City of Portland, Maine - Building or Use Permit

Permit No: 05-1636	Date Applied For: 11/08/2005	CBL: 189 A013001
------------------------------	--	----------------------------

Proposed Use: Commercial/ Addition of Non-heated Vestibule	Proposed Project Description: Addition of Non-heated Vestibule
--	--

RE: Olympia Equity Investors III, L.P.
Construction of Vestibule at 1230 Congress Street

3
A1 Floor Plan
SCALE: 3/8" = 1'-0"

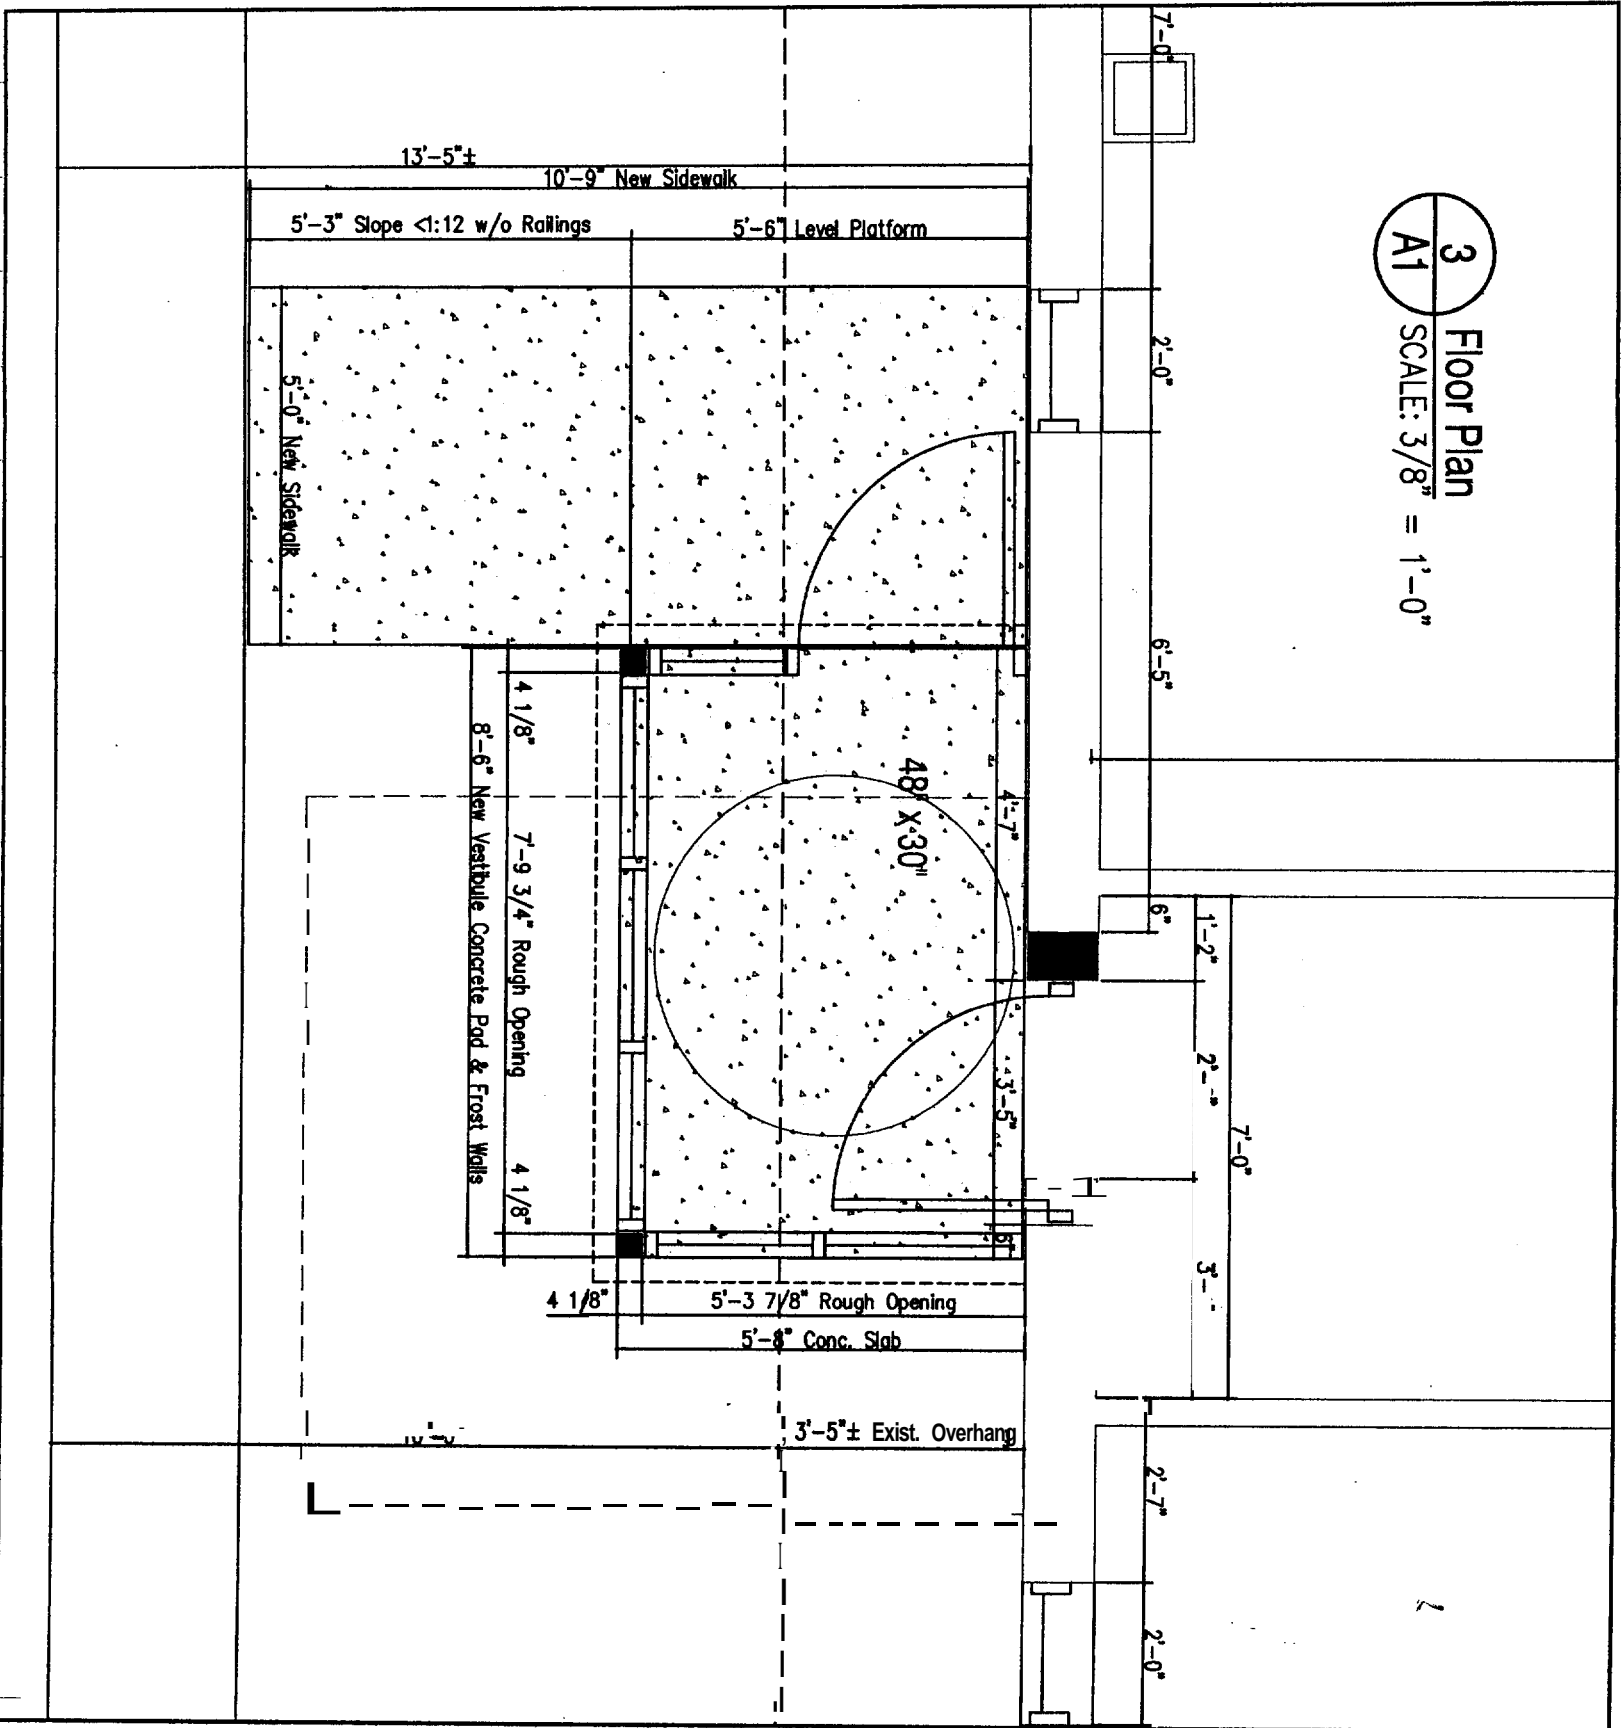
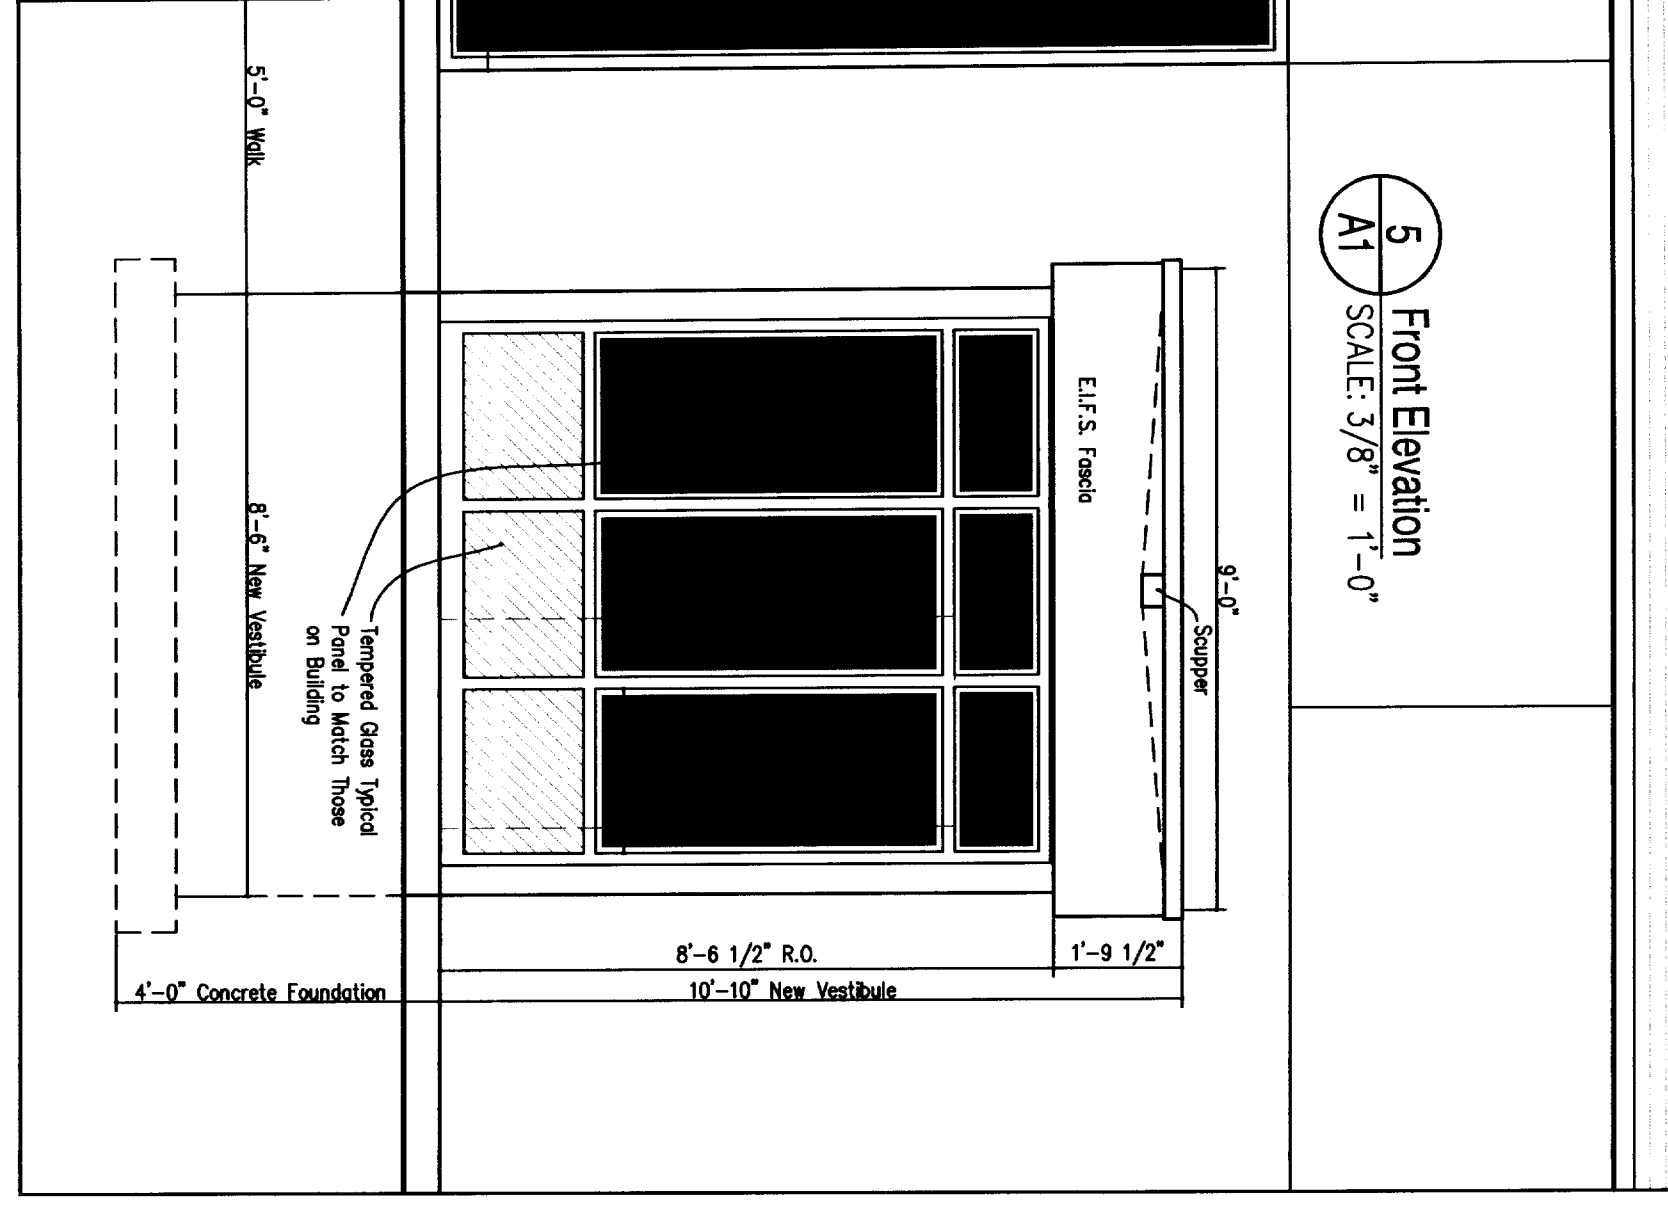
Dept: Zoning **Status:** Approved with Conditions **Reviewer:** Marge Schmuckal **Approval Date:** 0310812006
Note: 11/10/05 site plan exemption applied for. Called Ed Theriaut to let him know B-2 requires a 10' side setback - less than that is shown. Question as to whether the line shown is the actual property line - on hold in M's area
 11/18/05 Ed left a message that the owners are merging the property in question and he will get back to me when that is completed.
 3/8/06 received the quit claim deed showing that OEI III, llp is the owner of what used to be the state parcel, same owner as who owns the building in question. Gave to gayle to get the site plan exemption

- 1) This permit is being approved on the basis of plans submitted. Any deviations shall require a separate approval before starting that
